CITY OF ALBUQUERQUE

**Re: Martinez Hair Salon, 5801 Central Ave. NW,
 Permanent Certificate of Occupancy
 Engineer's Stamp dated 10-20-05 (K-11/D074)
 Certification dated 6-04-07**

Re: Martinez Hair Salon (K-11/D074)
119 58th St NW
Permanent Certificate of Occupancy
Certification dated 4/23/07

GRADING & DRAINAGE PLAN

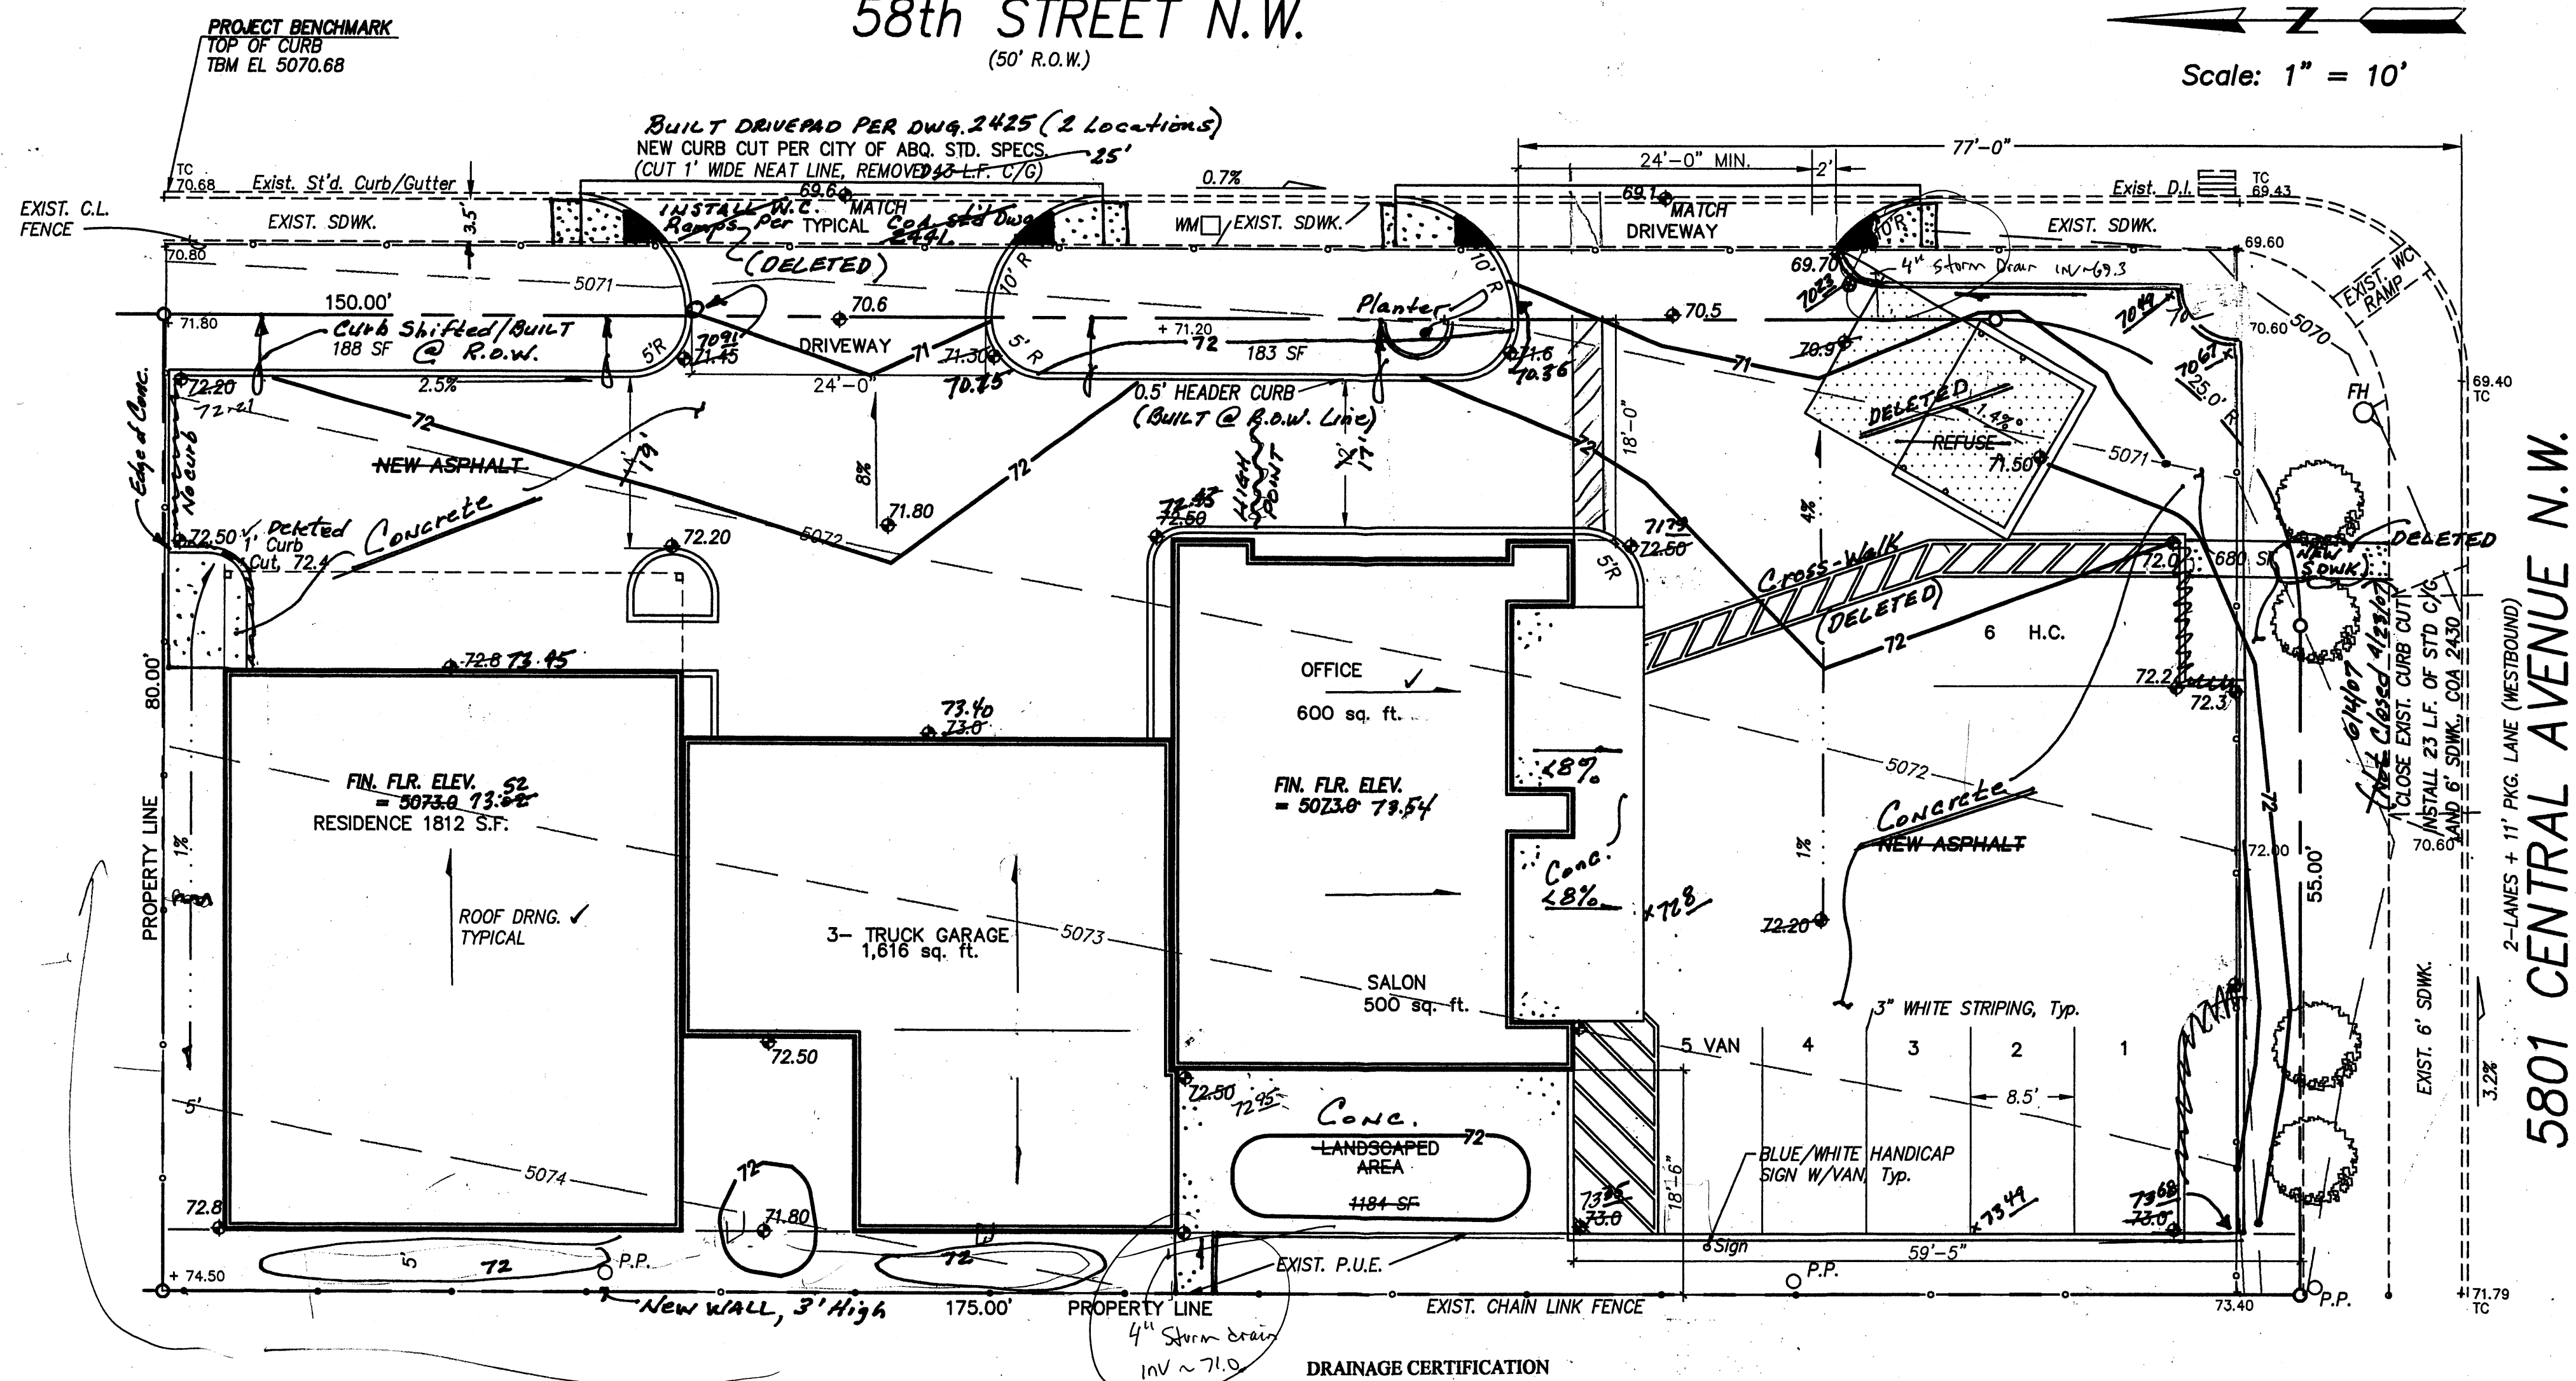
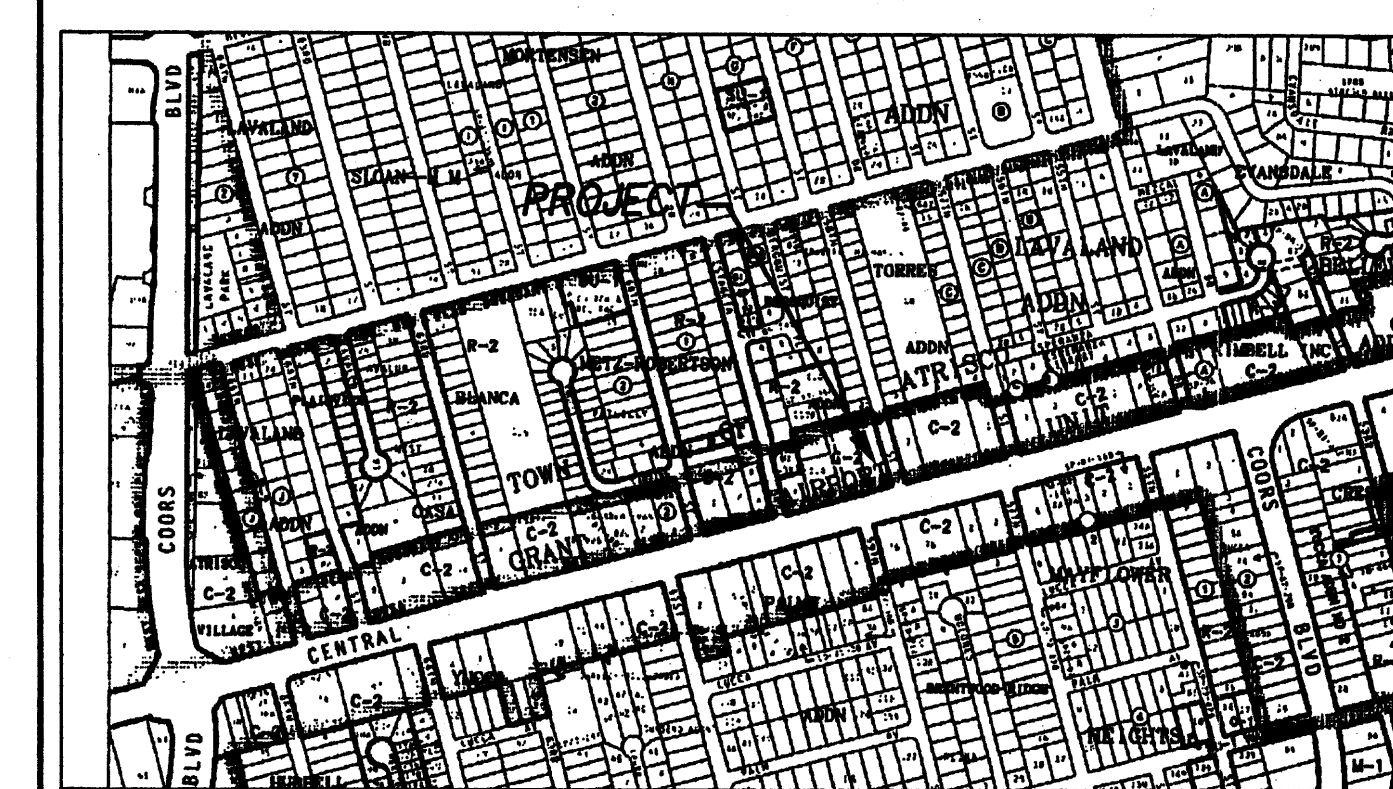
Told him that owner needed to
regrade the west and north sides around
the bldg so that runoff on the west side
will travel around to the north and out to
the street.

- The dirt area west of the buildings and the northwest corner will not drain. I could not gain access to the property due to fencing; however, it appeared that the northwest corner was approximately 1 foot low. There were also two scuppers on the middle building draining to this dirt area. The plan shows roof flows to the east.
- Also, not indicated on the plan is the cutout for a planter or similar near the handicap parking space.
- There also appeared to be a concrete patio (covered?) in the alcove of the middle building shown on the plan.

Per our telecon, I have requested the owner, as you suggested, to grade a swale from the NW corner and West Prop. Line earthen area north & around the North end of the bldg. to the east.
